Sent: 19 March 2012 17:00
To: Planning
Subject: Planning application N6/2012/0440/AD - Stanborough Beefeater

District ref: N6/2012/0440/AD
HCC ref: WH/124/2012
HCC received: 15/03/2012
Area manager: James Dale
Case officer: Lindsey Lucas

Location
Stanborough Beefeater
Stanborough Road
Welwyn Garden City
AL8 6DQ

Proposal
Erection of illuminated totem sign

Stanborough, Stanborough Road
 Welwyn Garden City
 Hertfordshire
 AL8 6DQ

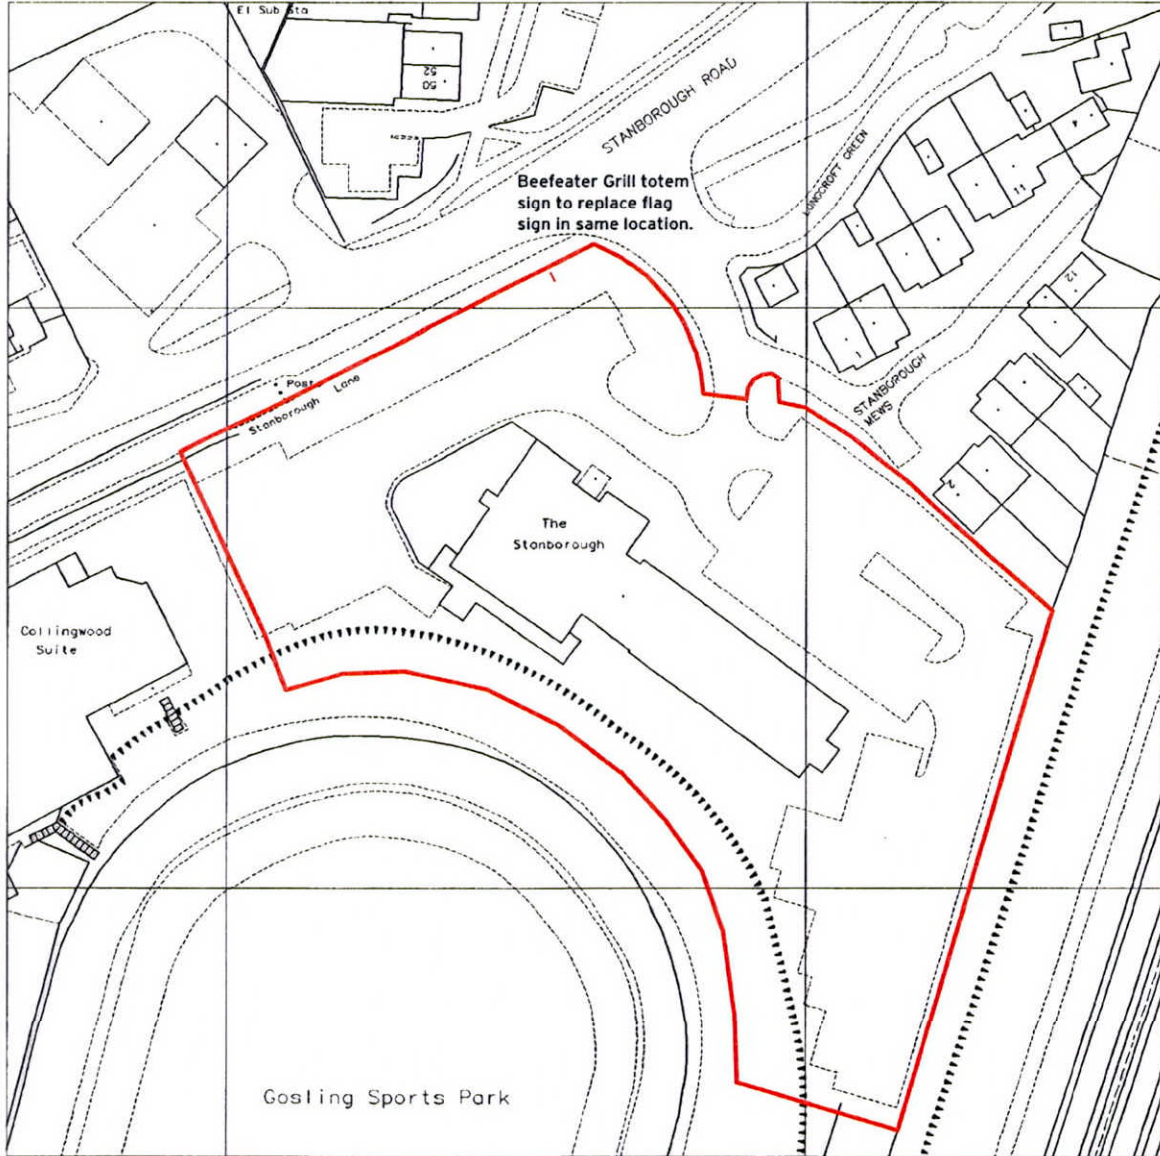
I am advised that the extent of public highway includes approximately 2m of the verge behind the combined cycleway/footway. Therefore the sign is located within the public highway and therefore cannot be condoned.

Nevertheless I acknowledge that land ownership is not an issue that has a bearing on consideration of the planning application and as there are no technical reasons to object to the sign a highway objection on encroachment grounds is not justified.

AN/. The applicant is advised that, notwithstanding any consent which may be issued under the provision of the Town and County Planning Acts it is an offence under Section 143 of the Highways Act 1980, to erect any advertisement sign in the confines of the highway. In this context "highway" includes any footway, verge, lay-by or carriageway which is maintained at public expense, in this case the verge extending beyond the back edge of the footway and encompassing the location of the proposed sign. The Highway Authority has the power under the Highways Act 1980, to remove any structure erected on a highway.
